Report of the Head of Planning, Transportation and Regeneration

Address 54C HIGH STREET NORTHWOOD

Development: Change of use of offices (Use Class E) to a one-bedroom dwelling (Prior Notification under Class MA of Part 3, Schedule 2 of the Town and Country Planning (General Permitted Development) (England) Order 2015 as amended).

LBH Ref Nos: 70476/APP/2022/706

Proposed Front Elevation

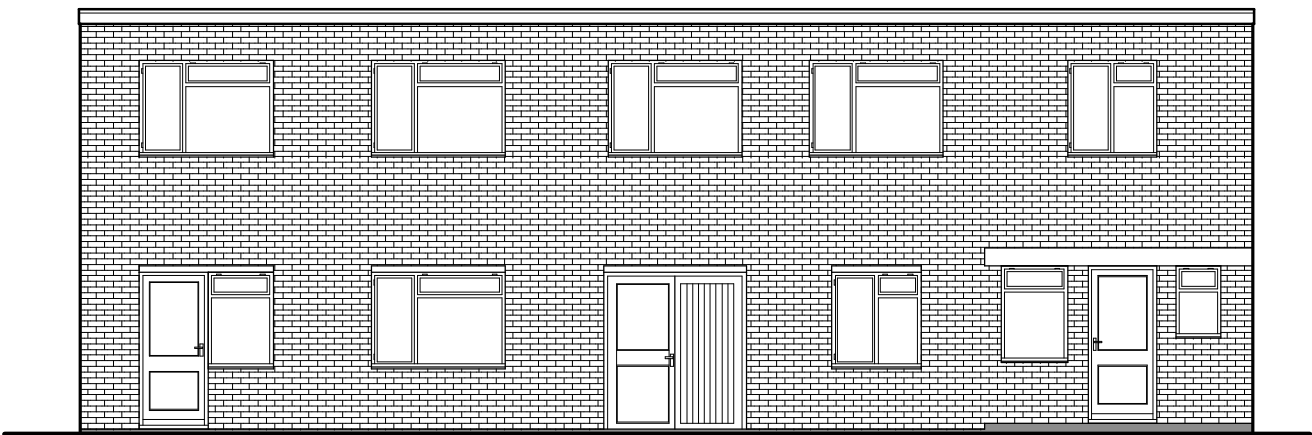
The proposed development would involve external changes to the property, including alterations to the door on the front elevation of the building. The proposed external changes would fall outside of the remit of Class MA, Part 3, Schedule 2 of the Town and Country Planning (General Permitted Development) (England) Order 2015 (as amended).

Class MA of the GPDO extends to change of use only and does not permit any external changes to the building for which planning permission is required. In this case, the submitted drawings clearly shows external alterations to the building, involving the partial replacement of the front double doors with a new door with what appears to have open glazing in its upper section. It is therefore considered that the proposed development would not comply with Class MA of the GPDO.

RESPONSE: The proposal is seeking alterations to the front elevation of the building that falls outside of the remit of this prior approval application. Refer to section 2.0 of this report for further details.
